DOC21/578460

State Significant Development SSD-10326042
Googong Primary School - GOOGONG NSW

ATTACHMENT 1: DETAILED COMMENTS FROM REVIEW OF EIS

SEDIMENT BASIN - WET

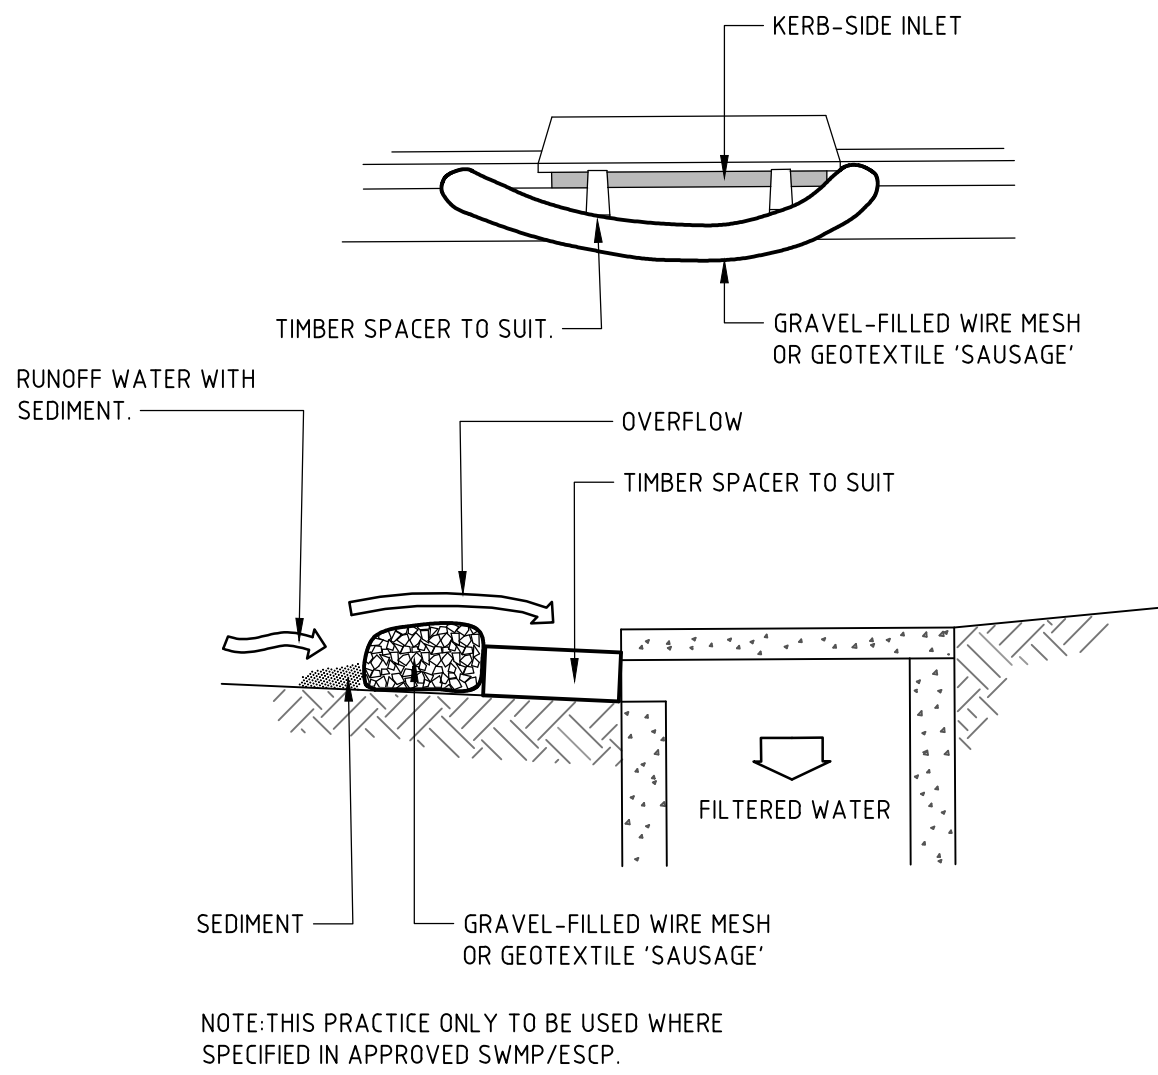
- 1. The EPA requires further information on the capacity, sizing, design rain event, catchment and management of the sediment basins***
- 2. The EPA reminds the proponent that it is an offence under section 120 of the POEO Act to pollute waters.***
- 3. The EPA recommends that a detailed Sediment and Erosion Control Management Plan is developed for the proposed construction prior to the commencement of works.***
